Our Ref: FG/119/15/A

Town & Country Planning (Control of Advertisement) (England) Regulations 2007 (as amended)
Application for Advertisement Consent

Development 1 No. non illuminated fascia sign, 3 No. non illuminated hoarding signs & 2 No. non illuminated panel signs.
Location Ferring Nurseries Littlehampton Road Ferring

Title: Site Location Plan

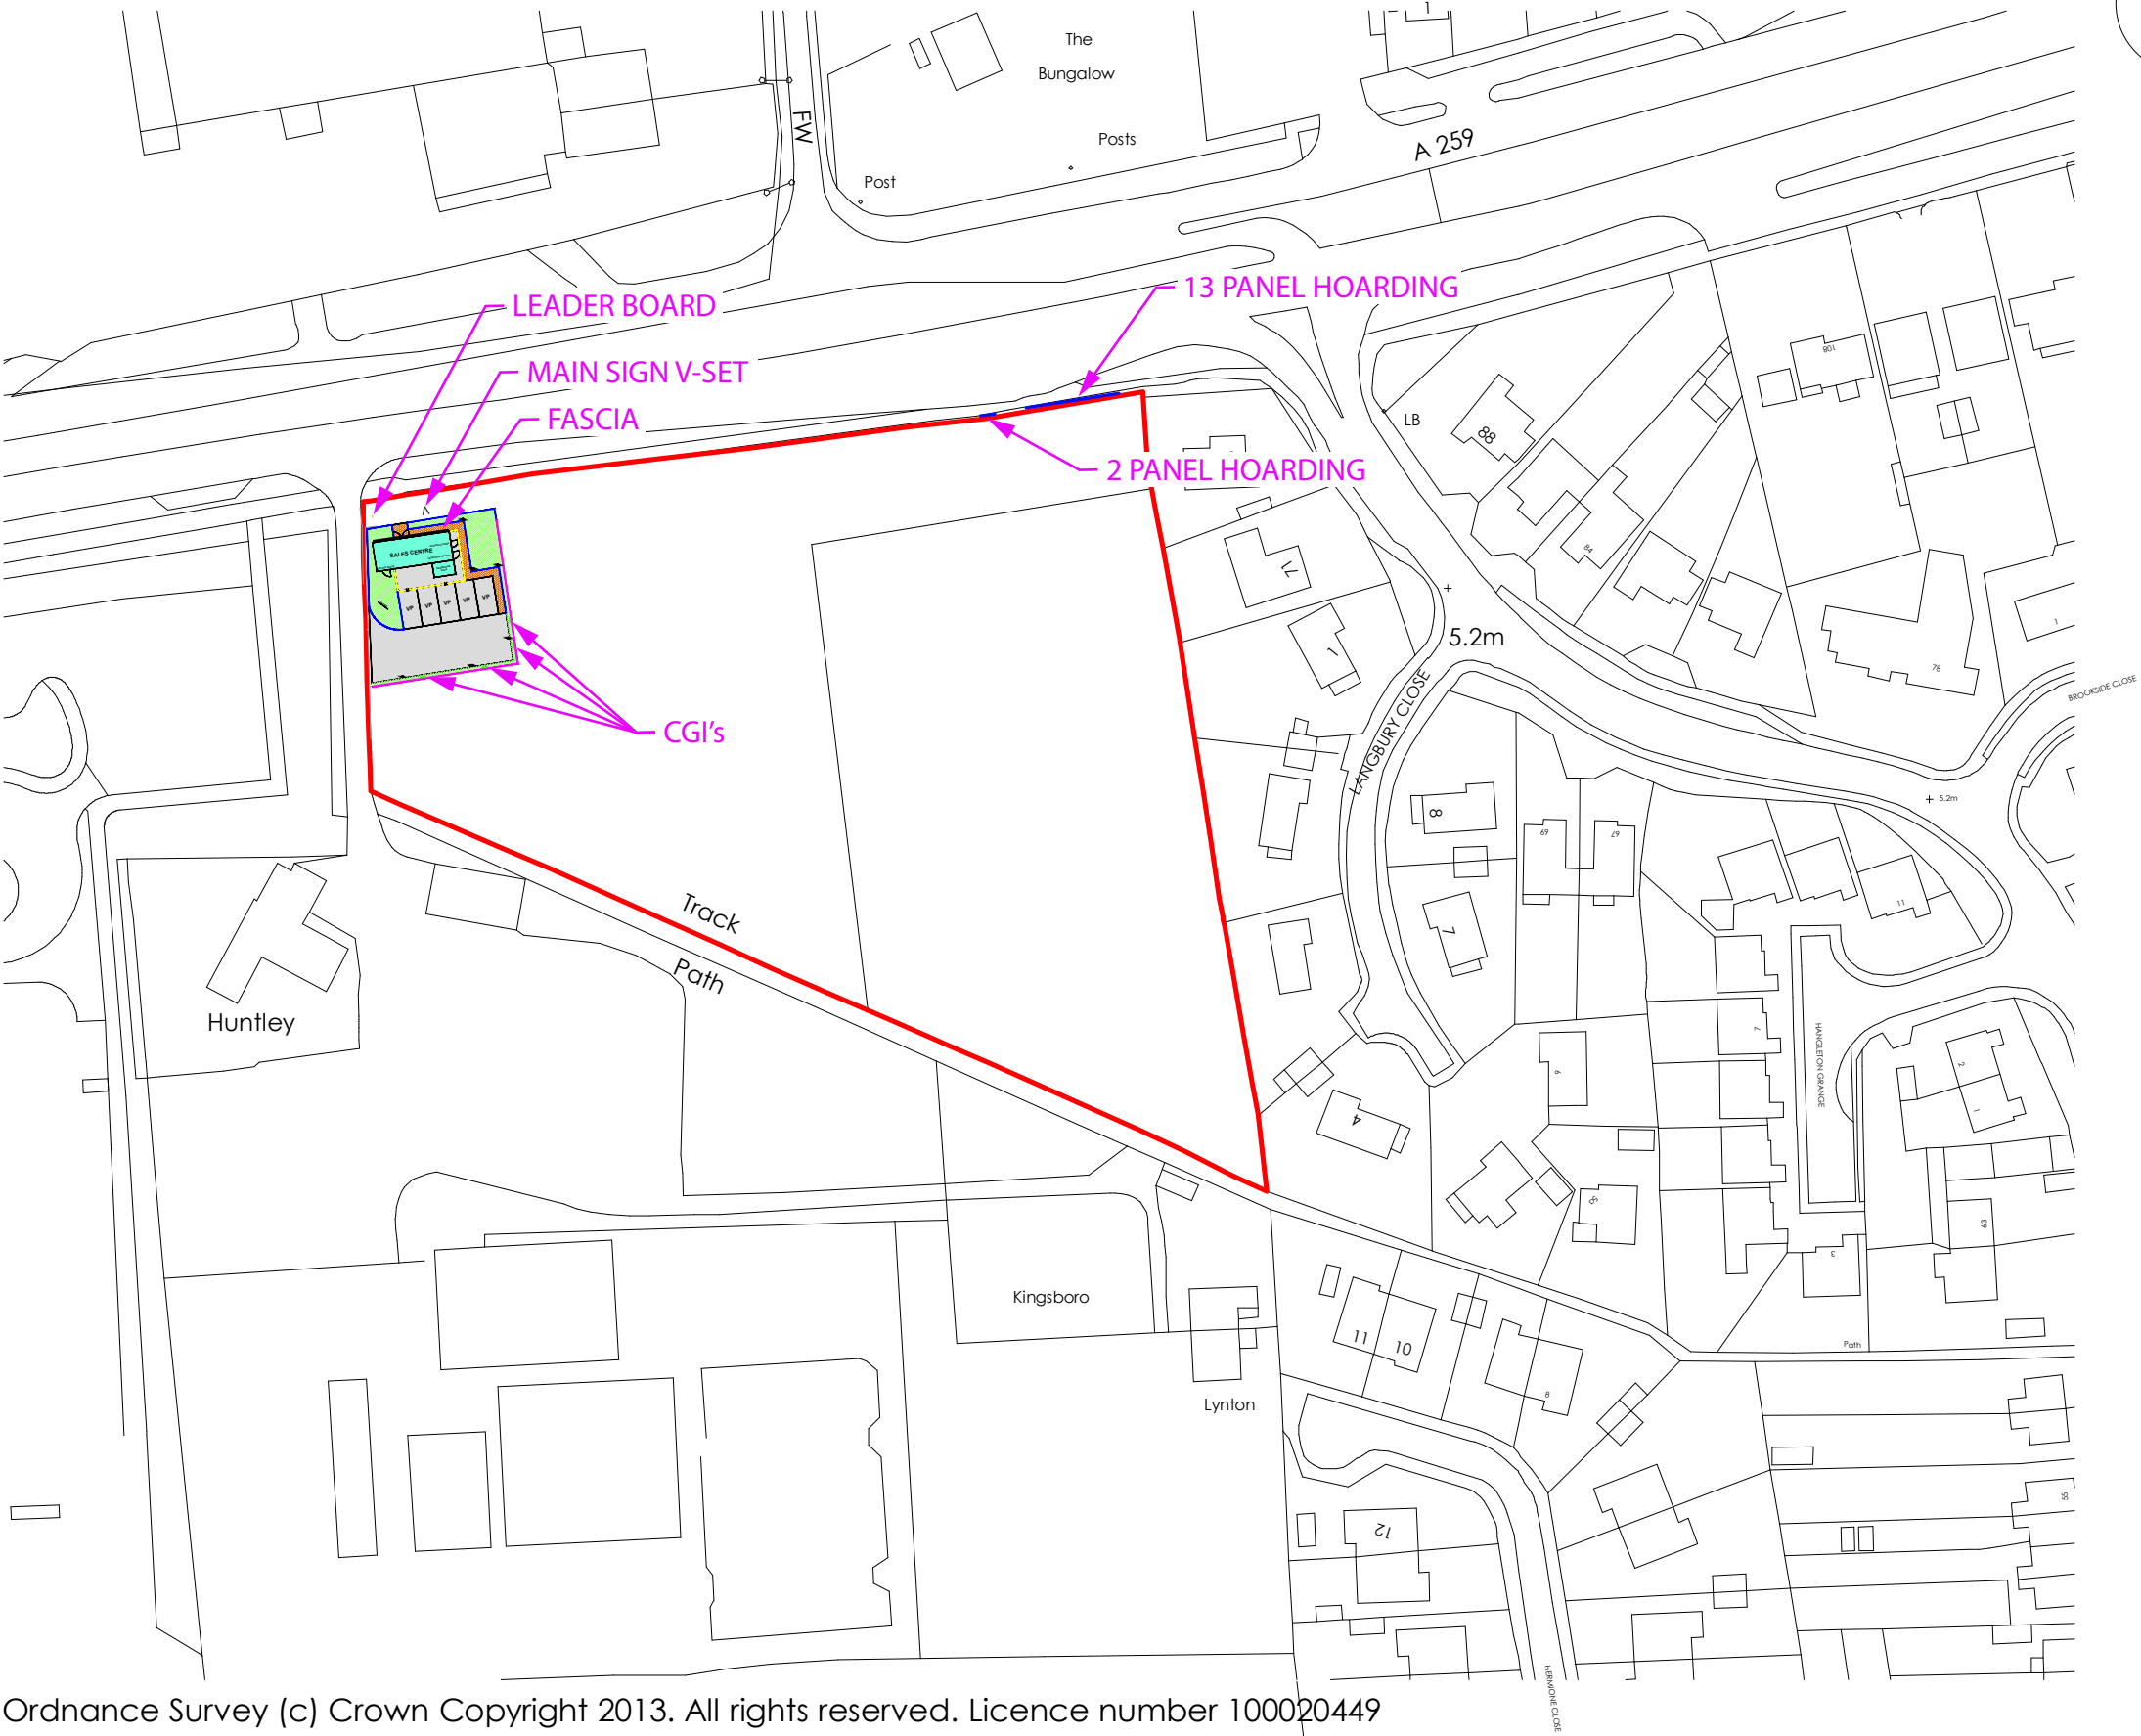
The plans submitted do not accord with the application form details.

Please clarify which sign on the application form description you wish us to change. I cannot see one called 'Main sign'.

Please amend the detailed plan submitted to include all signs and their positions clearly indicated on the plan (including those on the walls of buildings indicated by an arrow/colour etc).
